Application no: H02-0450-10

Description: Details submitted relating to Conditions 2, 3, 4, 5, 6, 7, 9, 13, 14, 15, 16, 17 and 18 of H02-0657-08)

Location: 61 South Street
Crowland
Peterborough
Cams
PE6 0AH
PE6 0AH

Amendment: Side hung casement windows
(dwg. nos. 844-01-01-PD01D and 844-01-01-PD02D)

Drawing No.
844-01-01-PD02

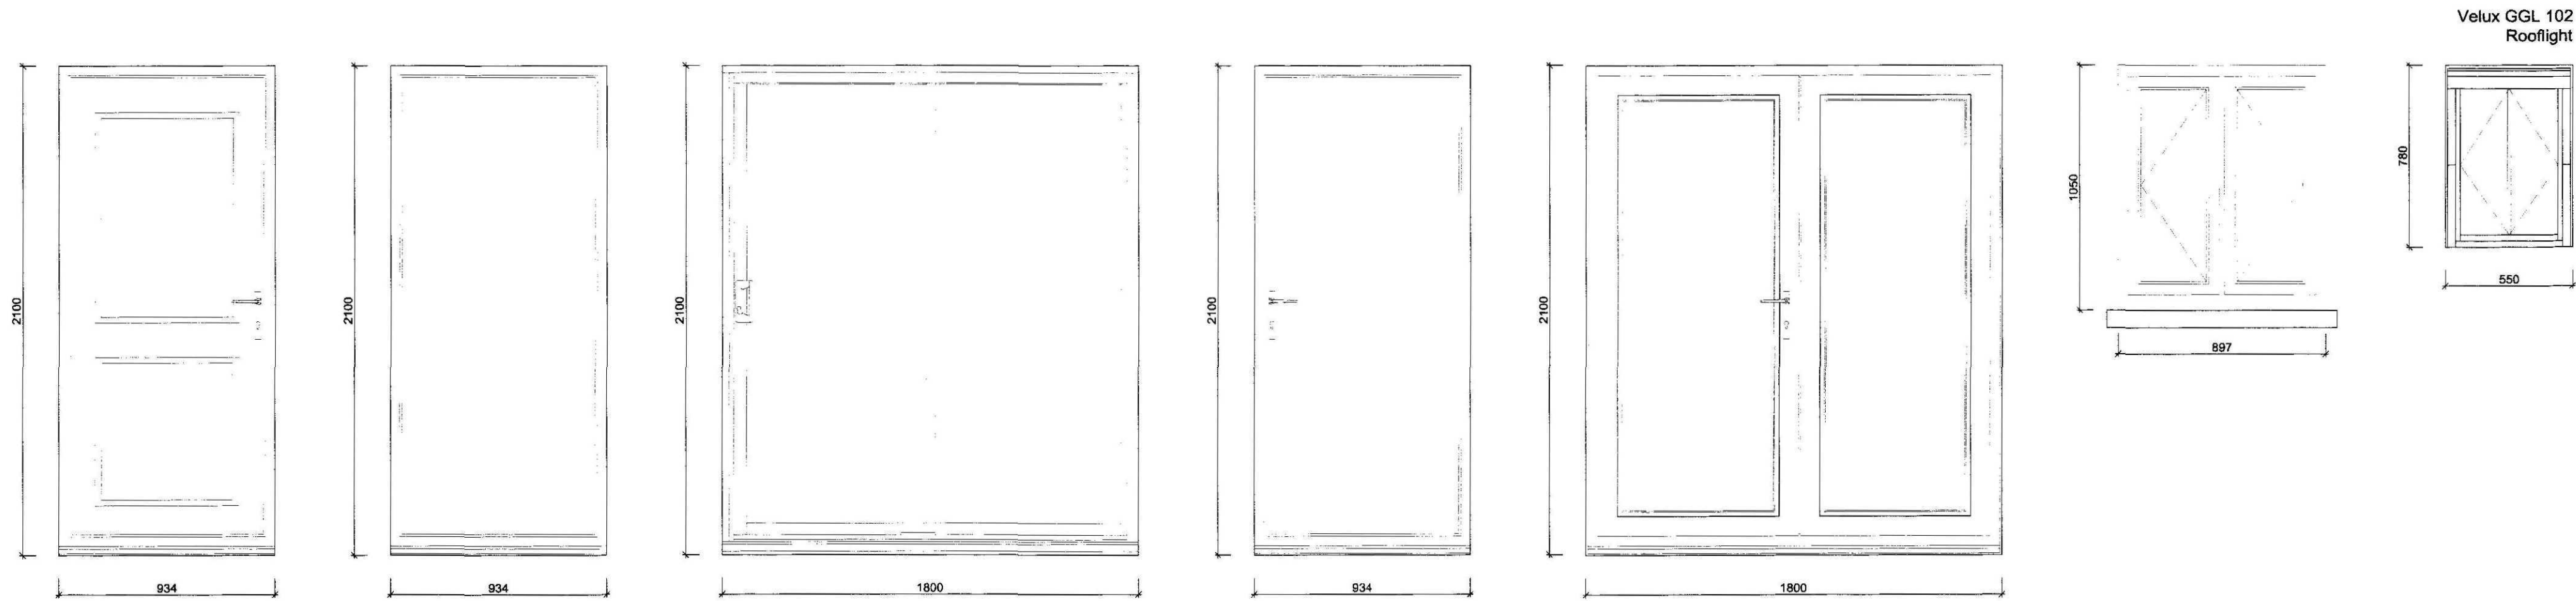
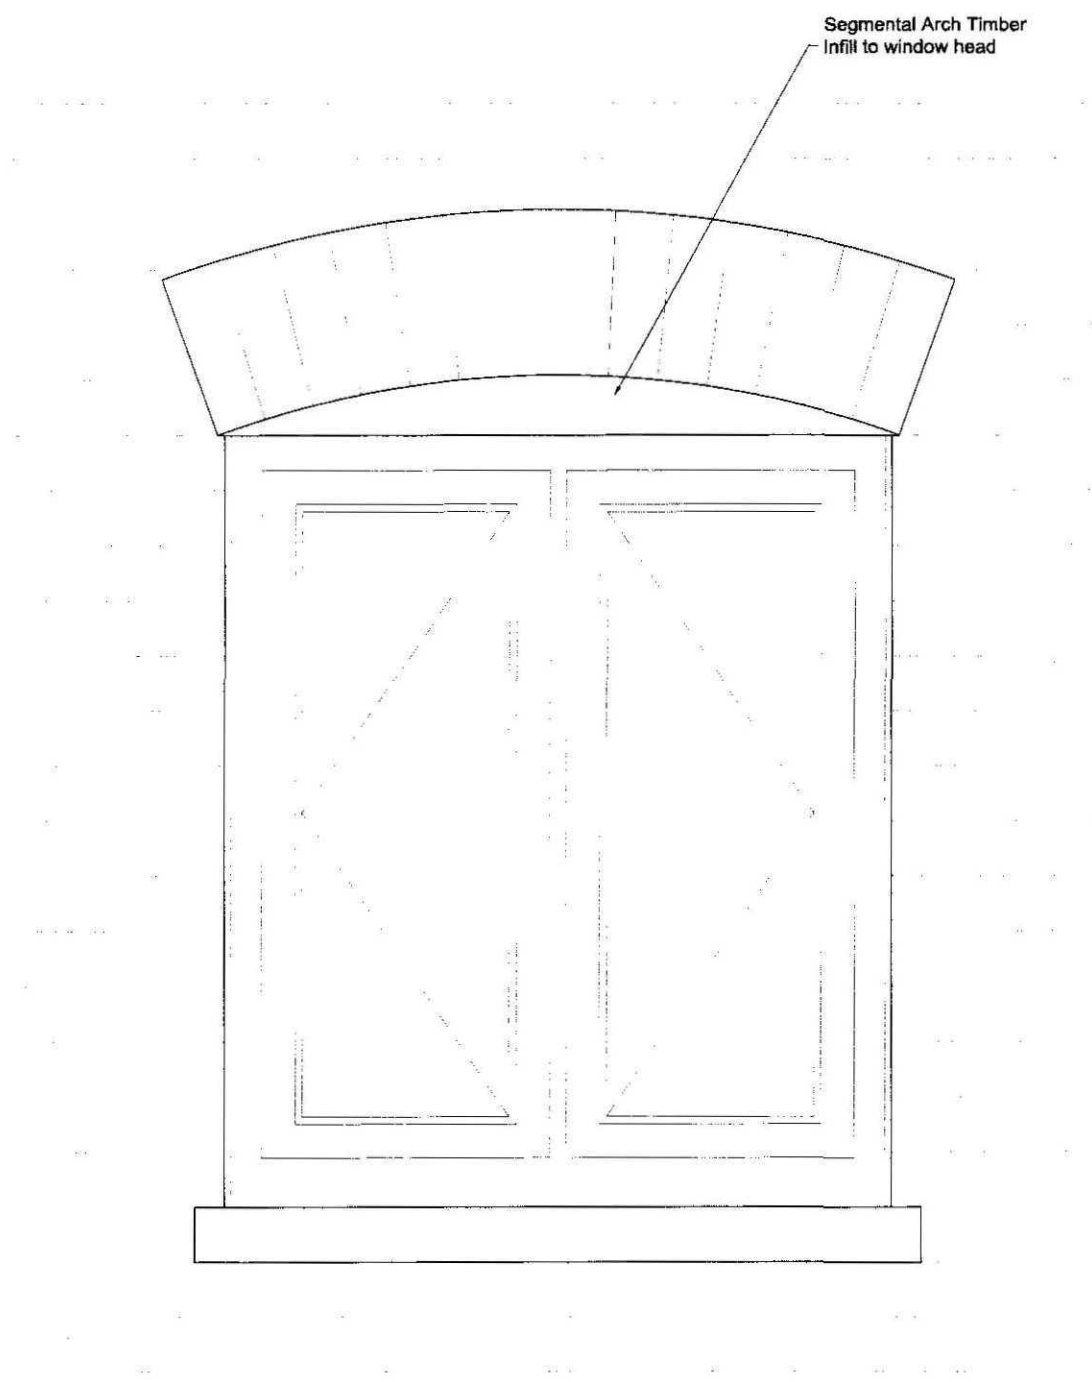
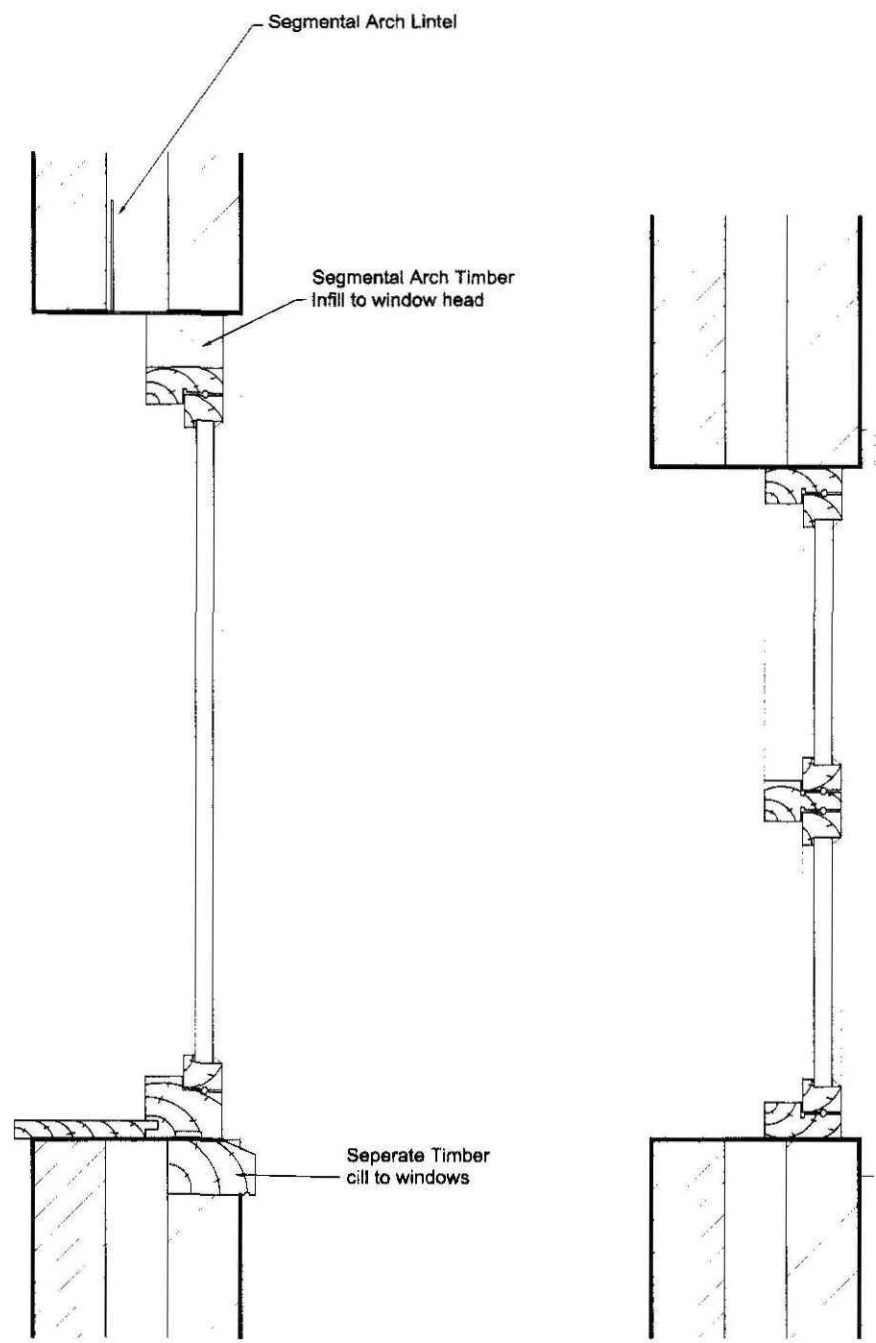
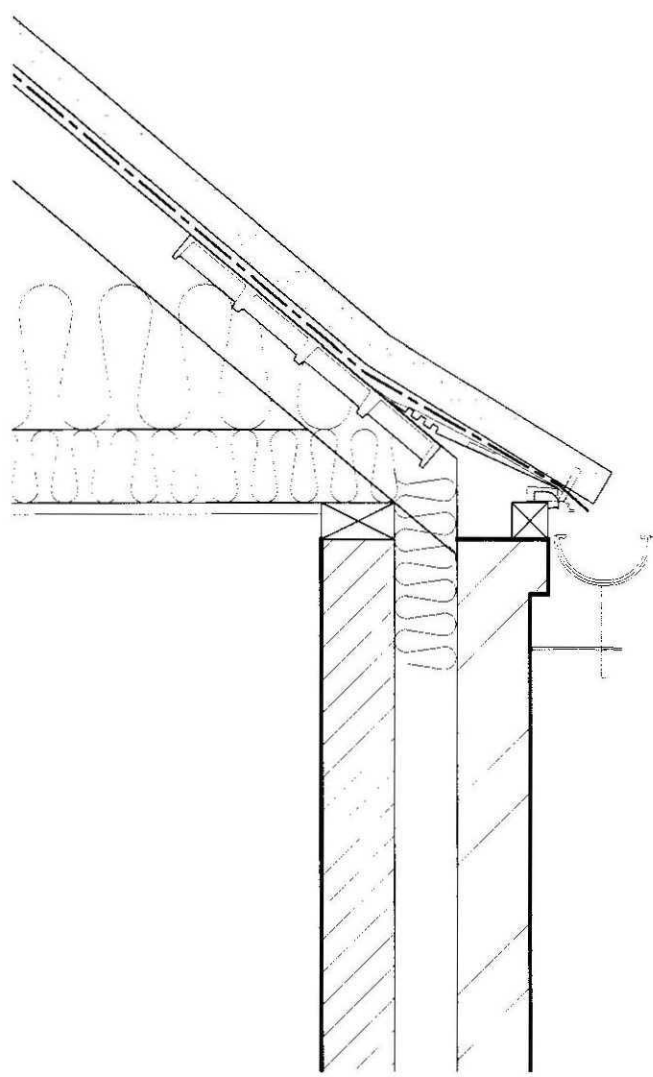
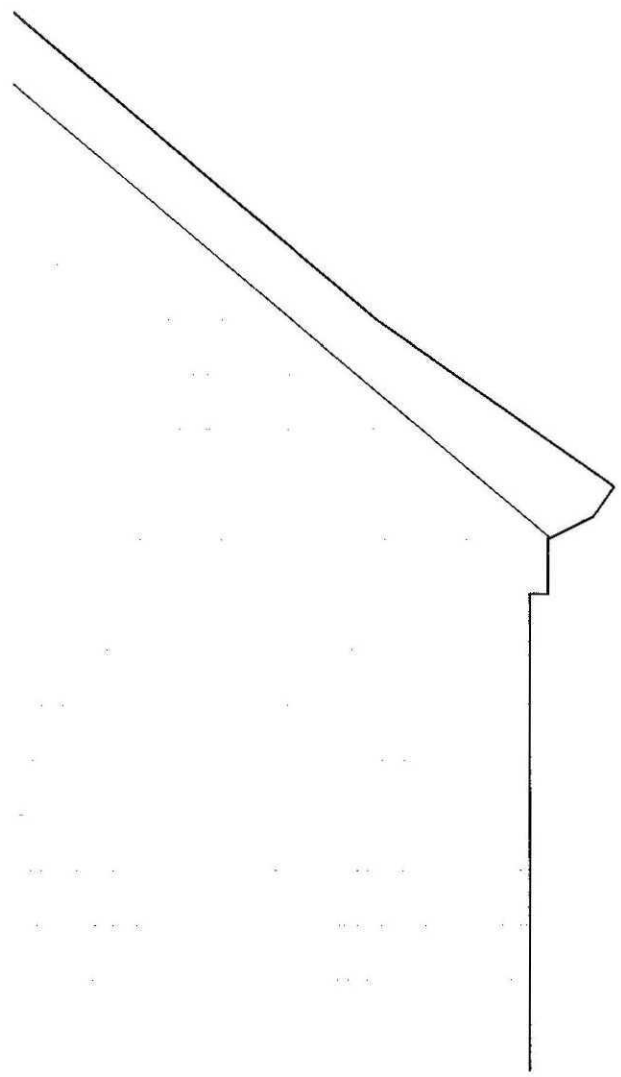
Attached are the agreed details for the two plots with the addition of the note stipulating the use of arch lintels.

Also attached are the revised windows for the replacement. I hope these are in accordance with our discussion.
